Attachment 1 Department of Planning, Industry and Environment Comments

Mamre Road Precinct

Civil Engineers and Project Managers	at&l	Level 7, 153 Walker Street North Sydney NSW 2060 ABN 96 130 882 405 Tel: 02 9439 1777 Fax: 02 9923 1055 www.atl.net.au info@atl.net.au
Status	FOR APPROVAL NOT TO BE USED FOR CONSTRUCTION	A1
Project - Drawing No.	18-596-C1010	Issue C

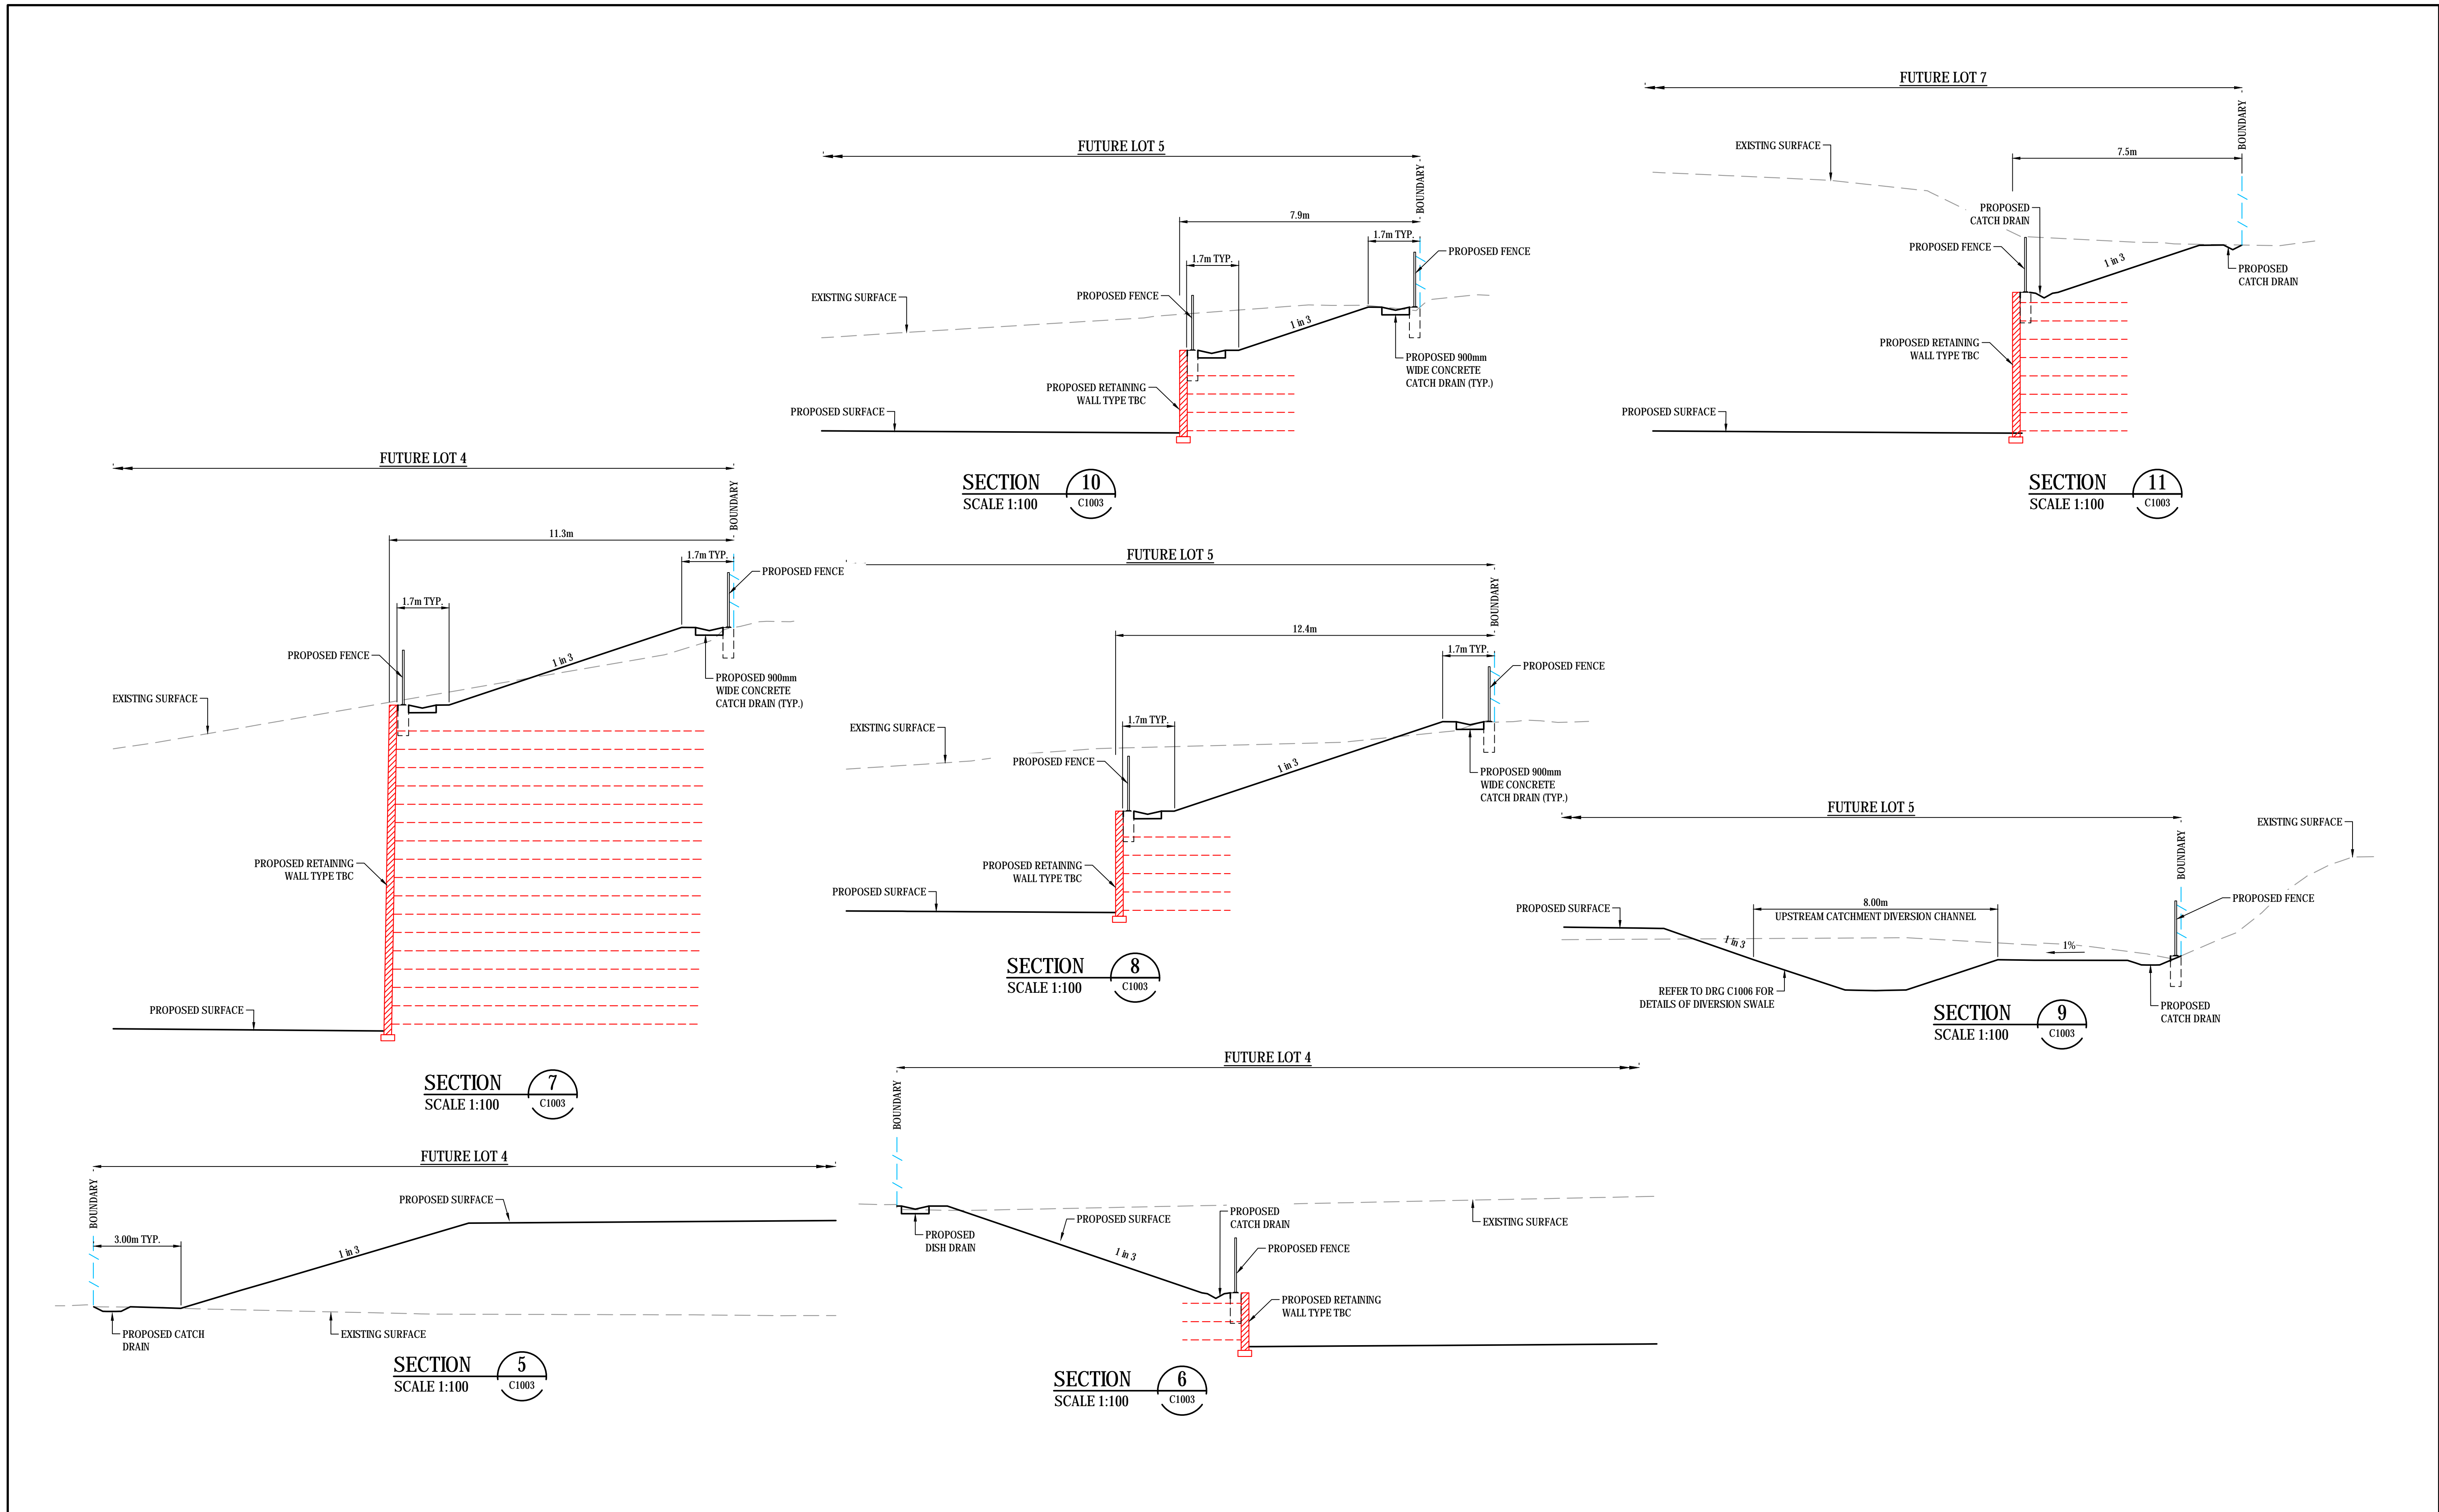
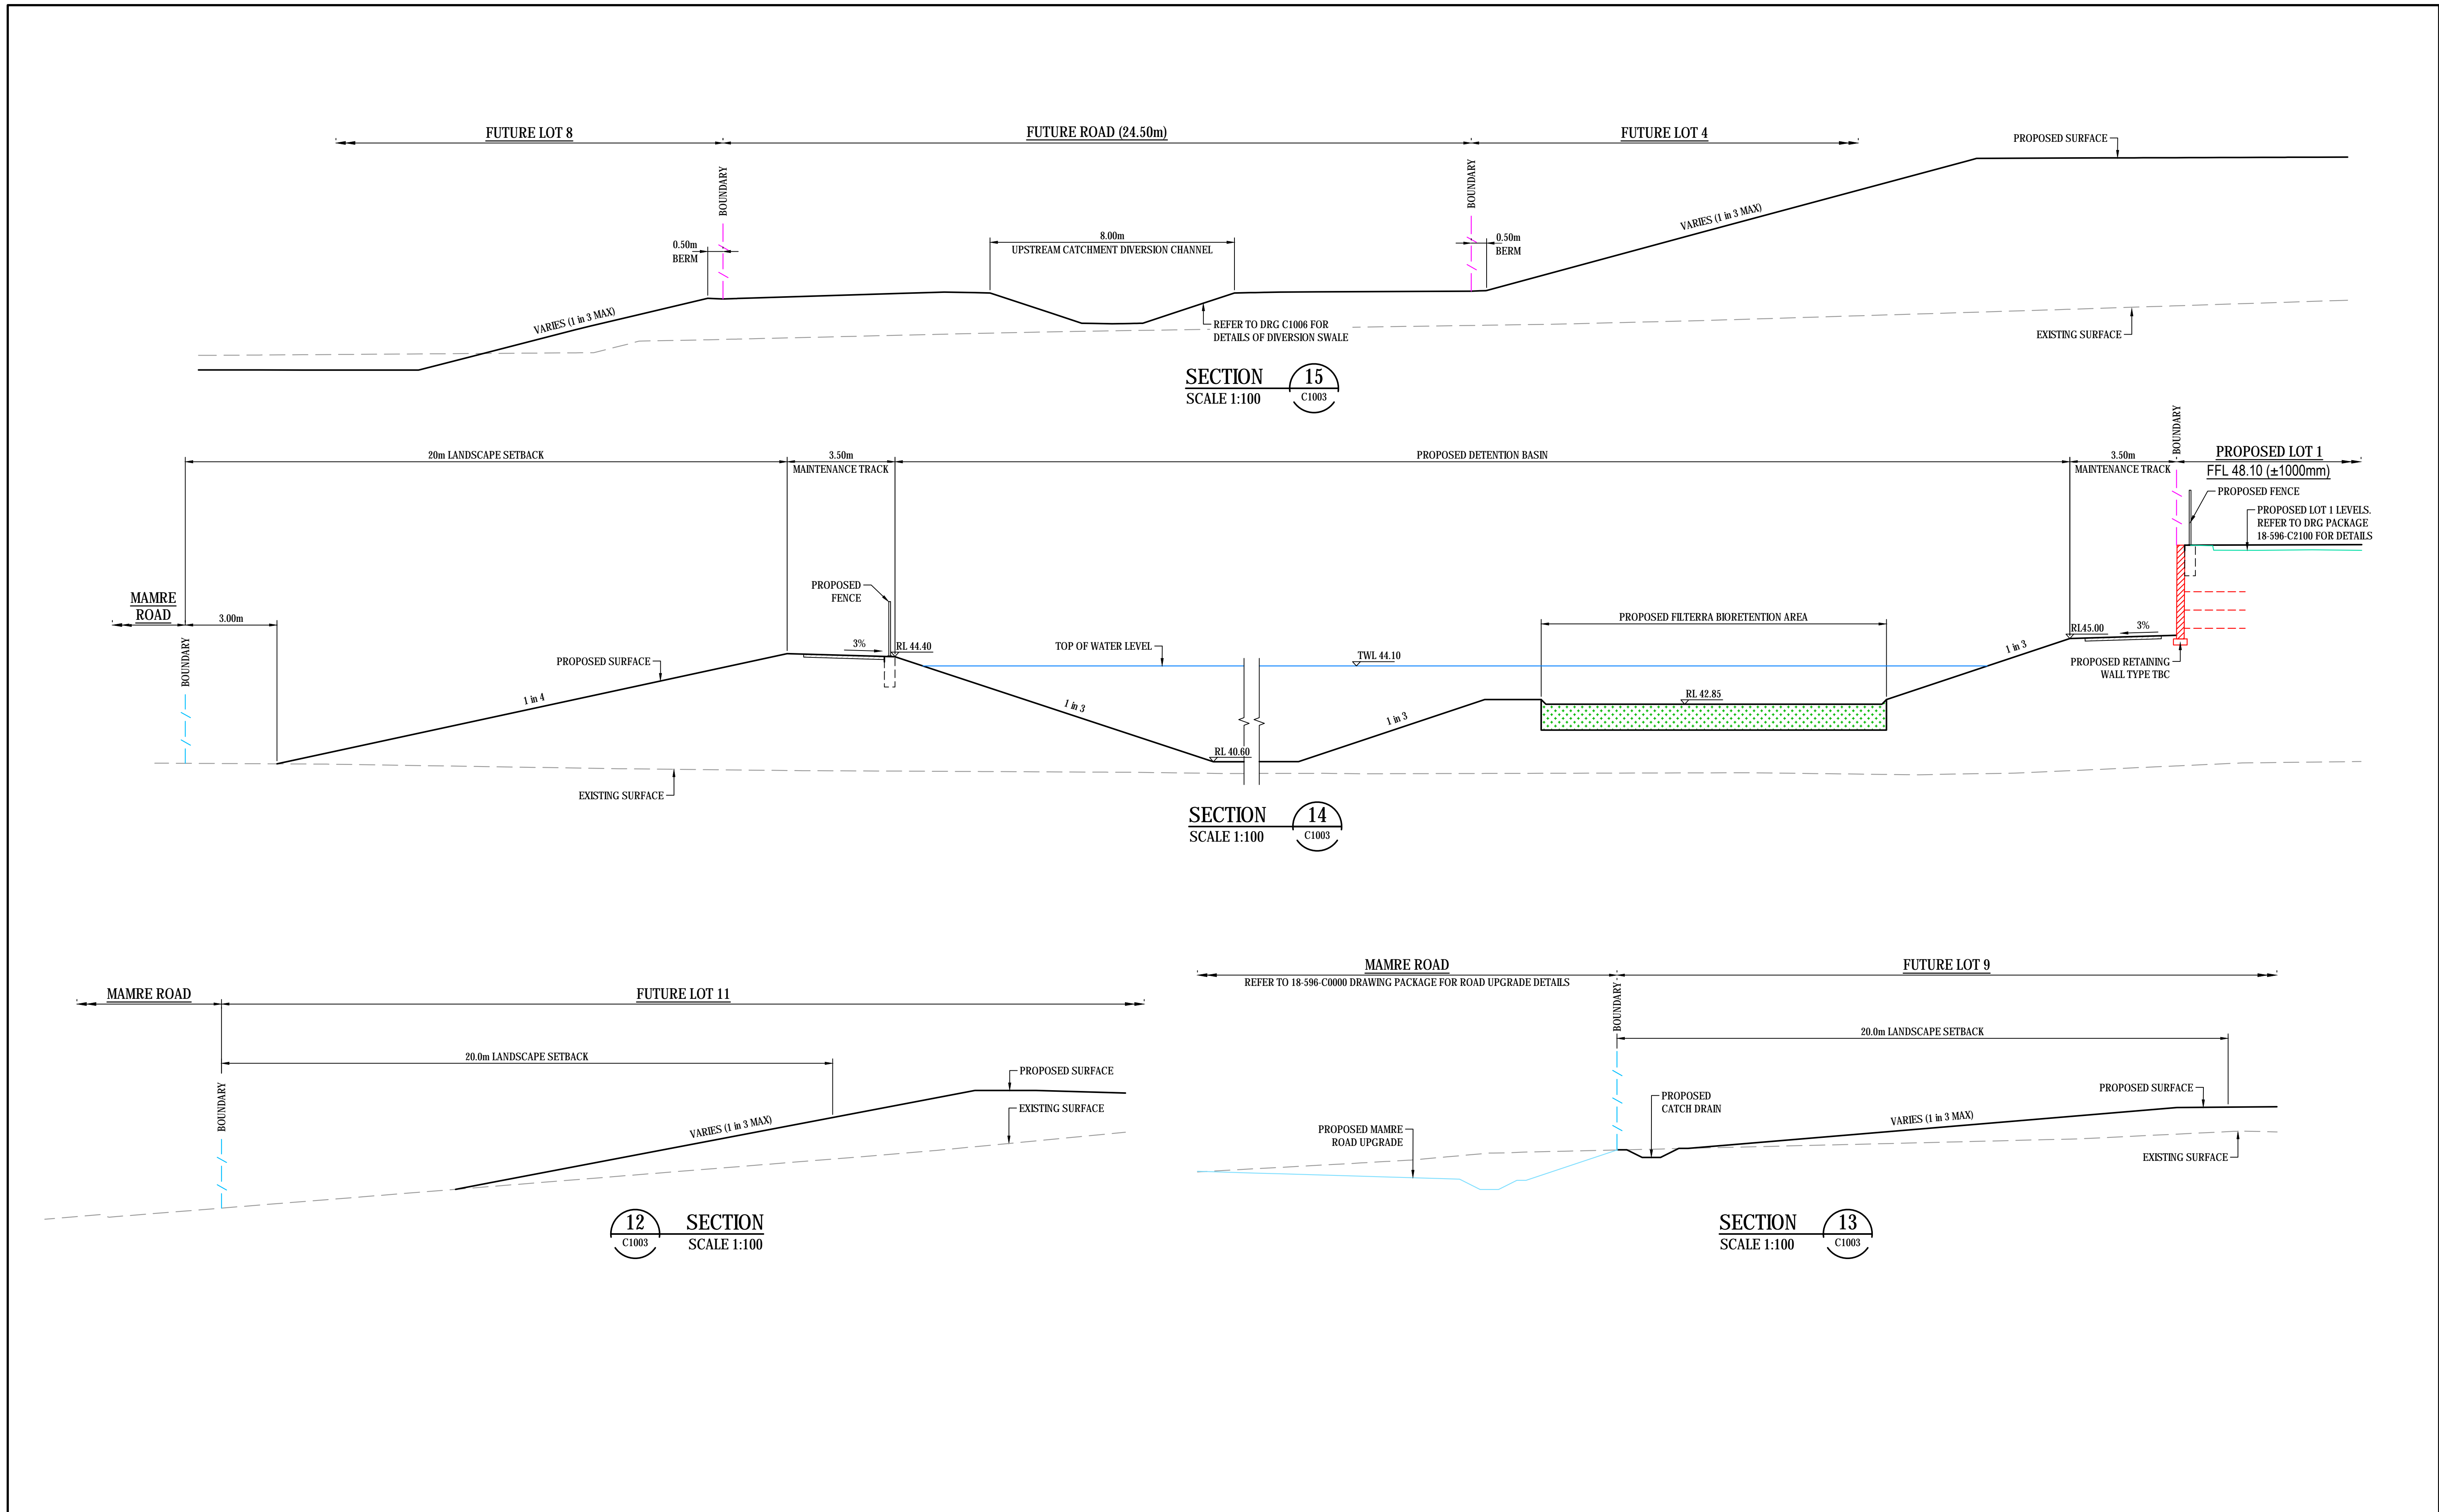
14. The Department notes the width of the proposed creek channel is inconsistent between documents. The Riparian Assessment Report states the channel would be 4.75 m wide, whereas Sections 1 and 2 in the Civil Drawing (No: 18-596-C1010) show the low-flow channel would be 5.6 m and 5.7 m wide respectively. Furthermore, the typical riparian corridor section in Civil Drawing (No: 18-596-C1006) shows a 3.75 m wide low-flow channel within a 20 m wide high flow channel. Please clarify the width of the channel.
